GELOTTE HOMMAS DRIVDAHL
ARCHITECTURE

RE: Seifert Remodel & Addition

Building Permit # 2403-052

Land Use Permit # SHL24-005

SITE DETAILS

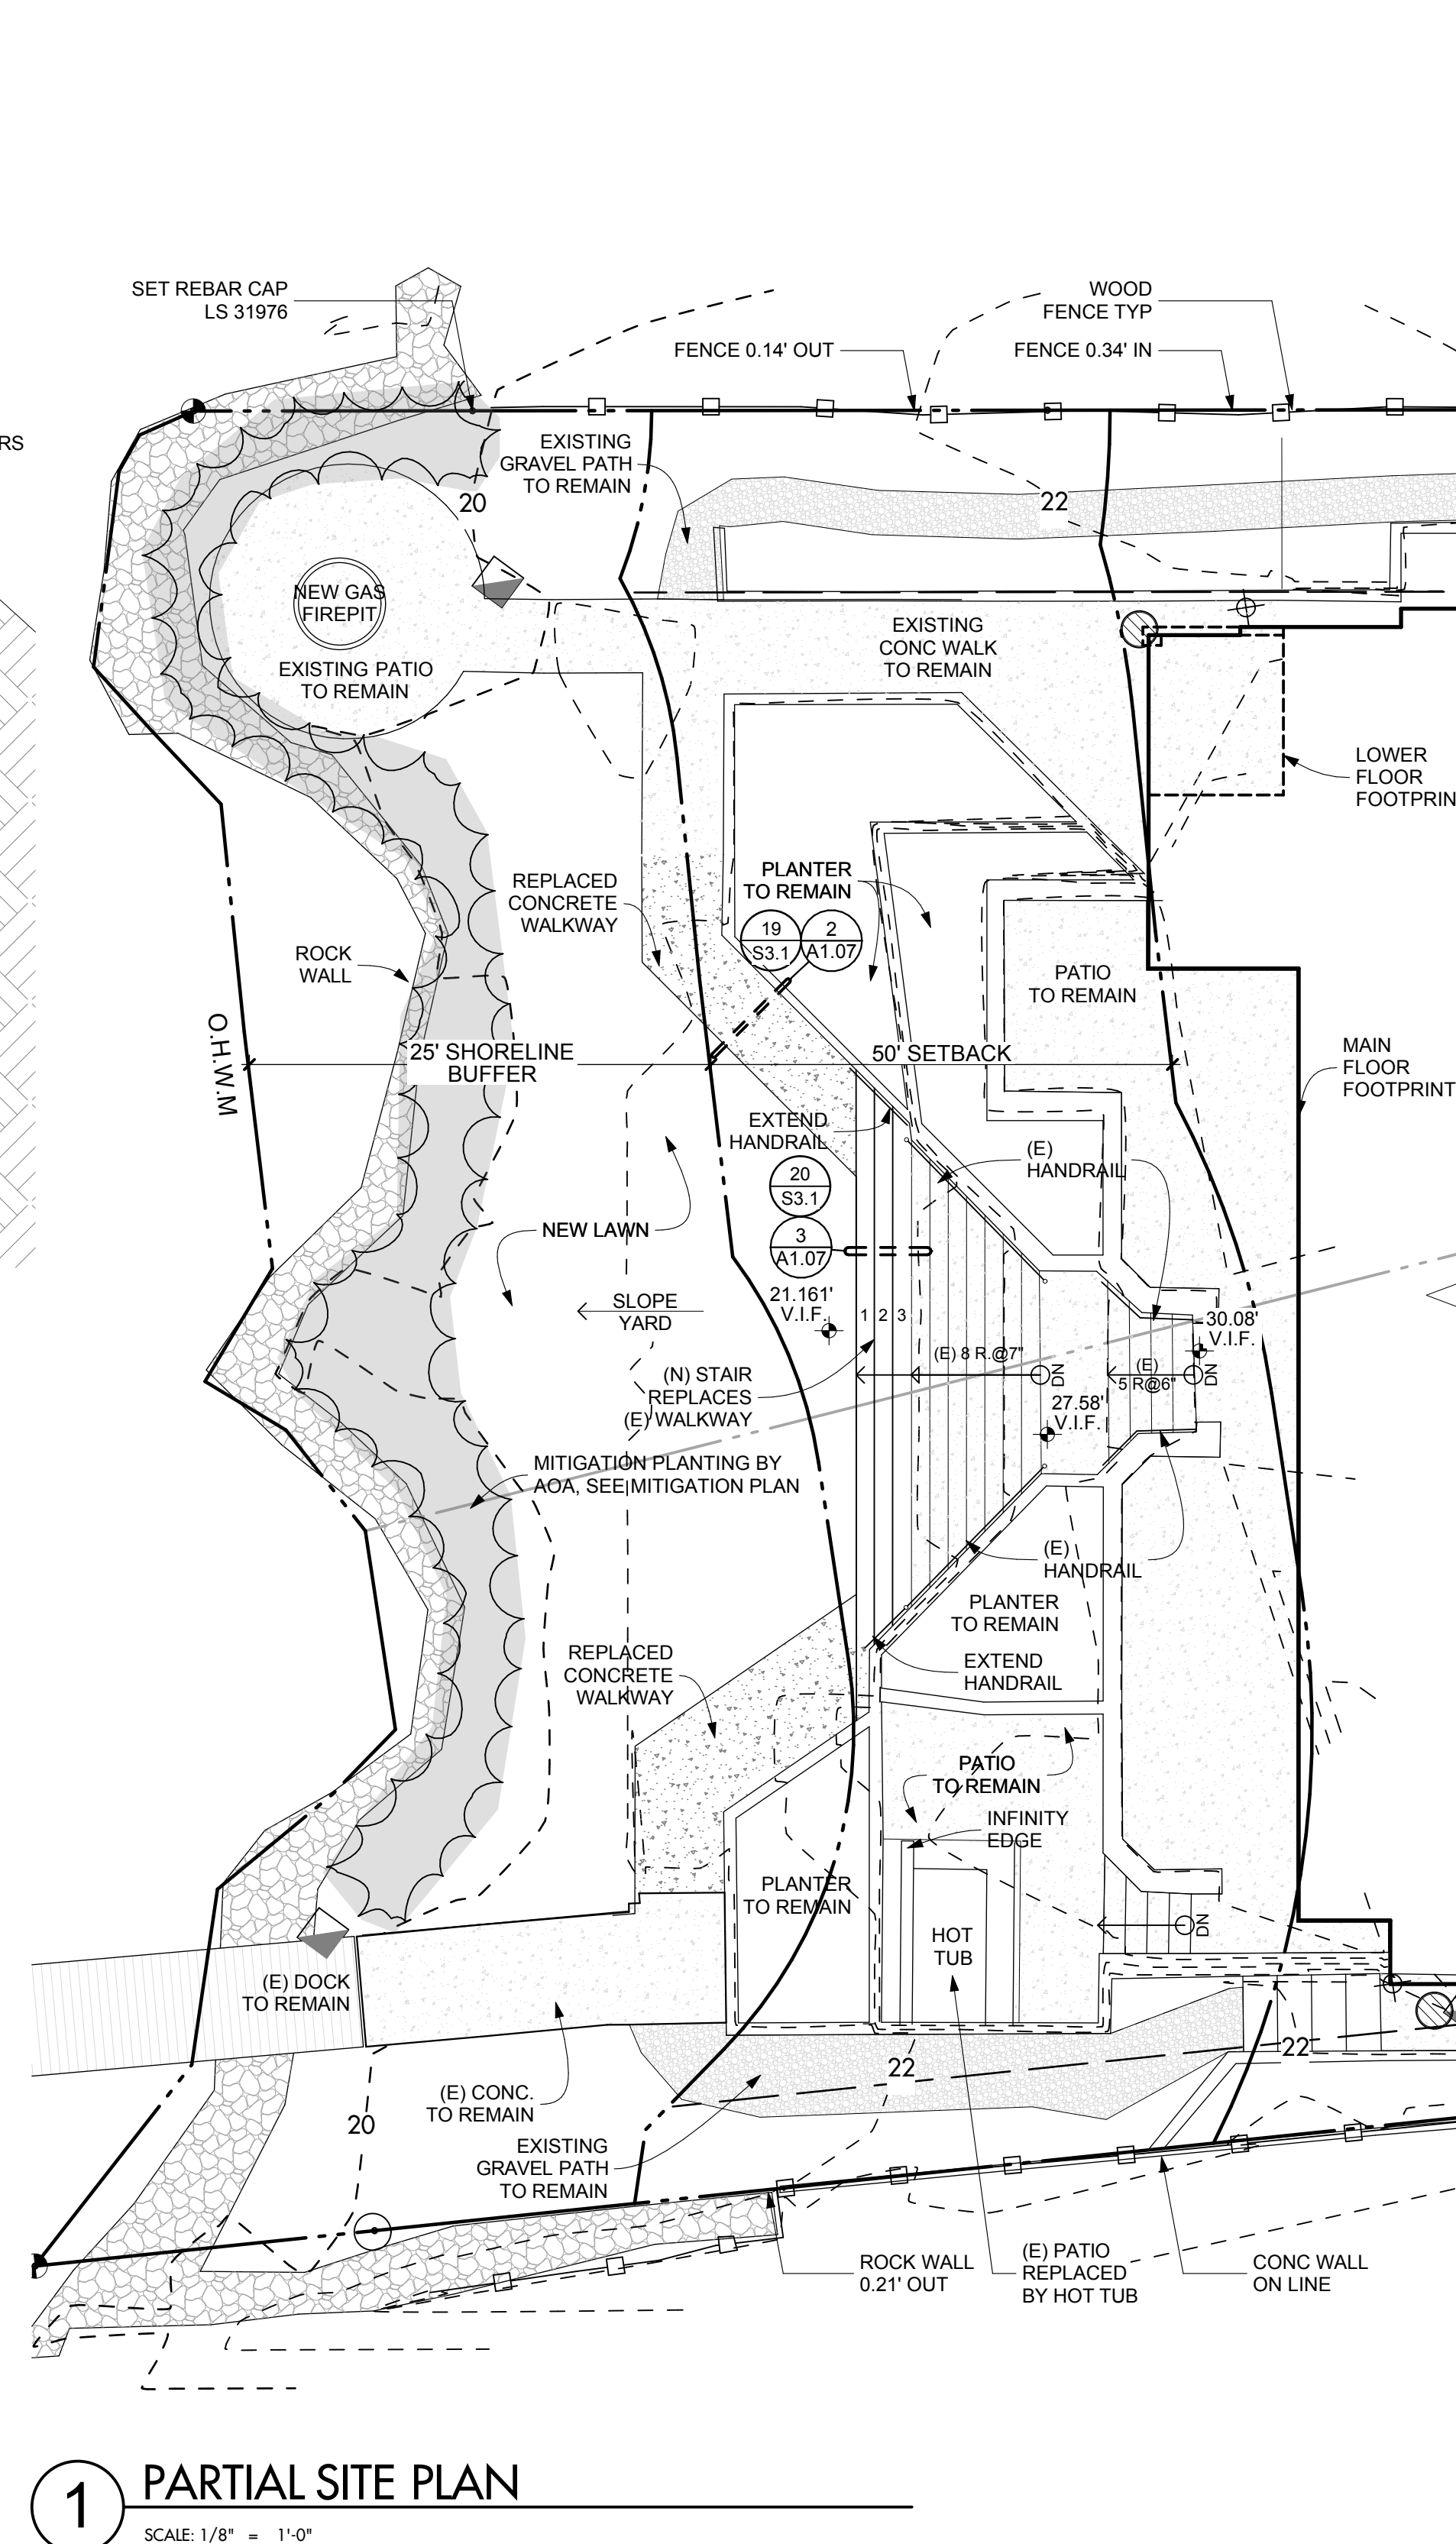
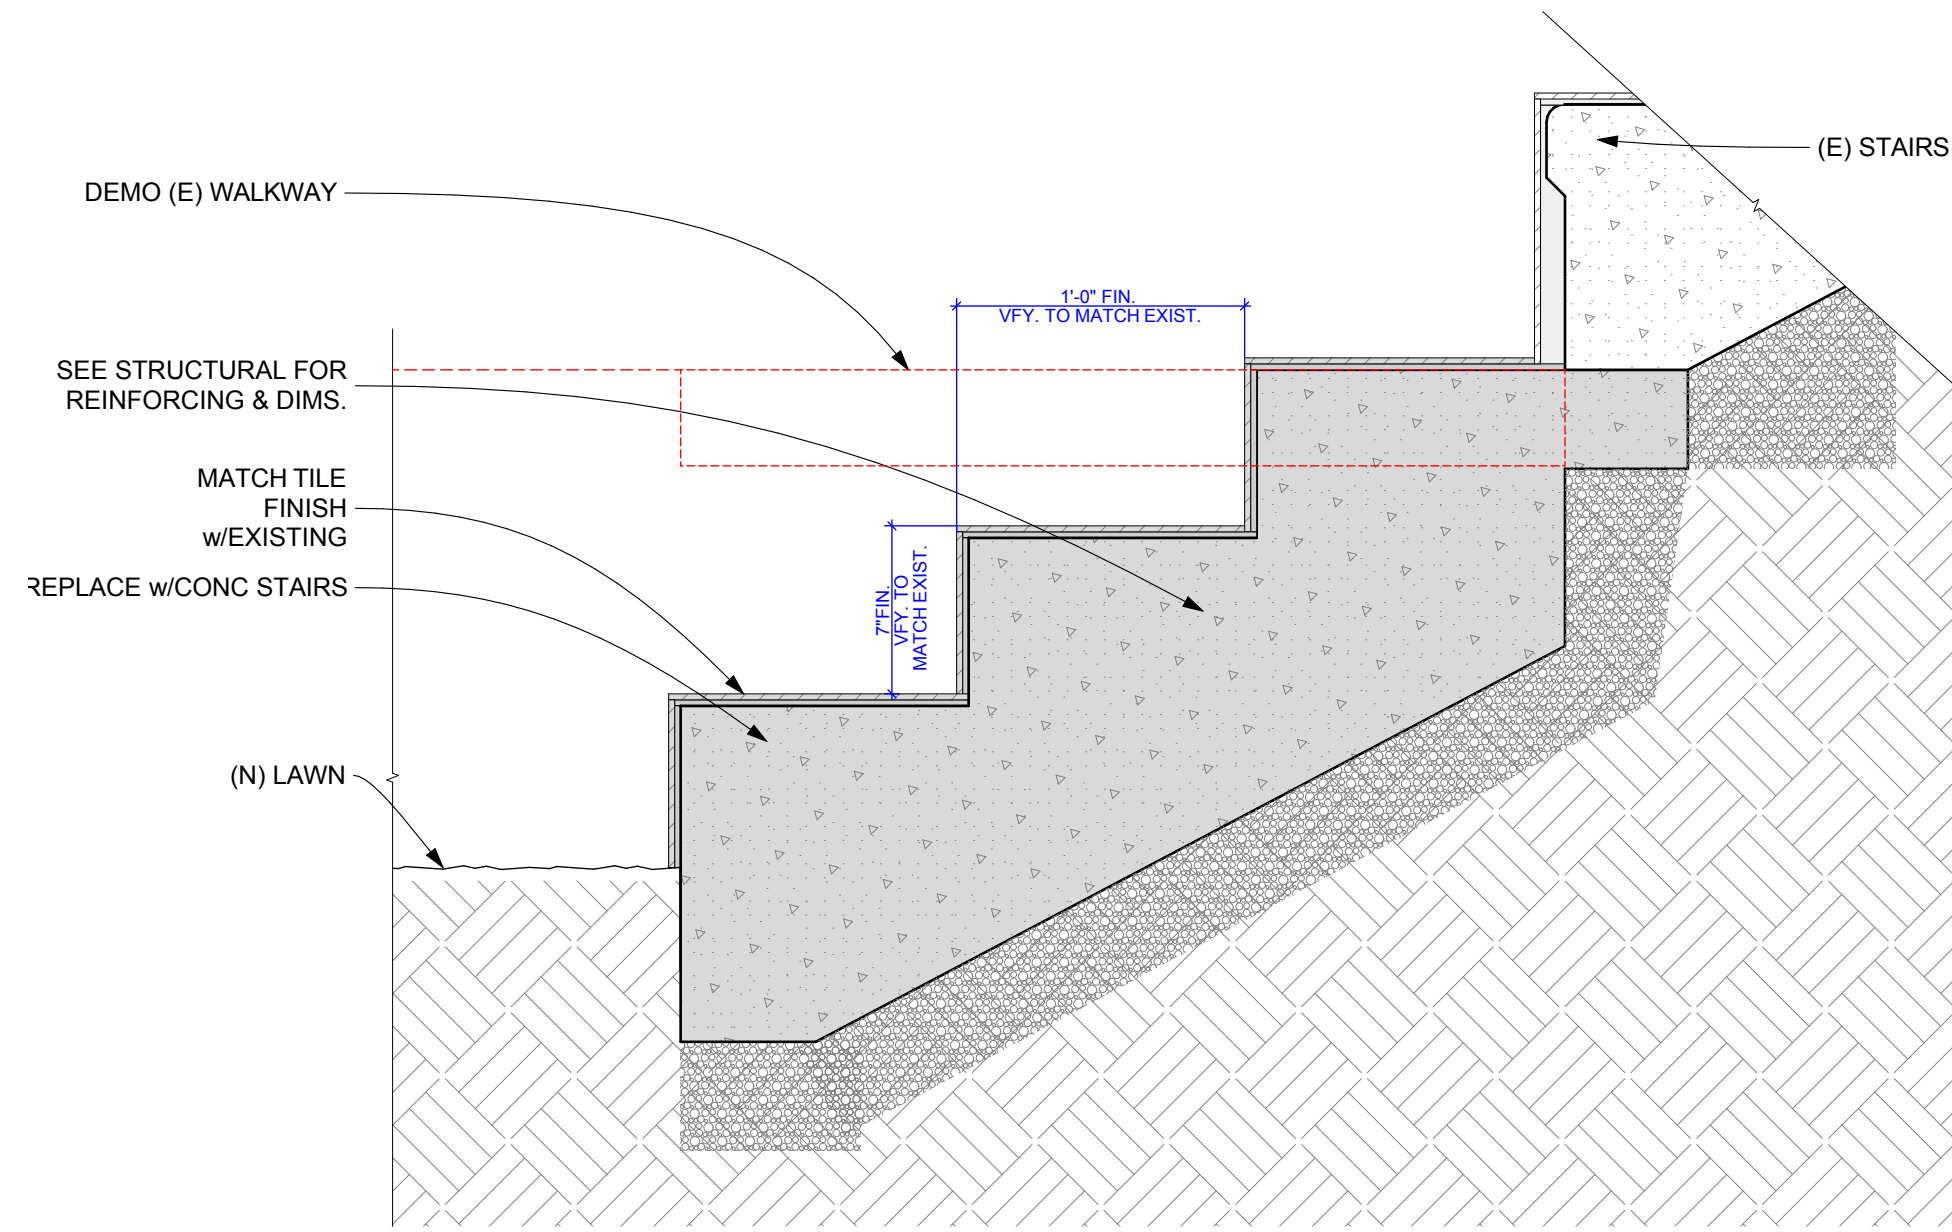
The owners of the subject property have decided to propose no changes to the 25' area immediately landward of the OHWM. Additionally, they are proposing no changes to the entire westward side of the site from existing planters and existing site stairs. There are several reasons for this revised proposal.

Please reference the updated plan set showing the existing legal non-conforming structures, walkways, lawn and grading in the area 25' landward from the OHWM and westward from existing planters and site stairs to remain. Likewise, please remove the Altman Oliver Associates plans from consideration for your initial review of the project.
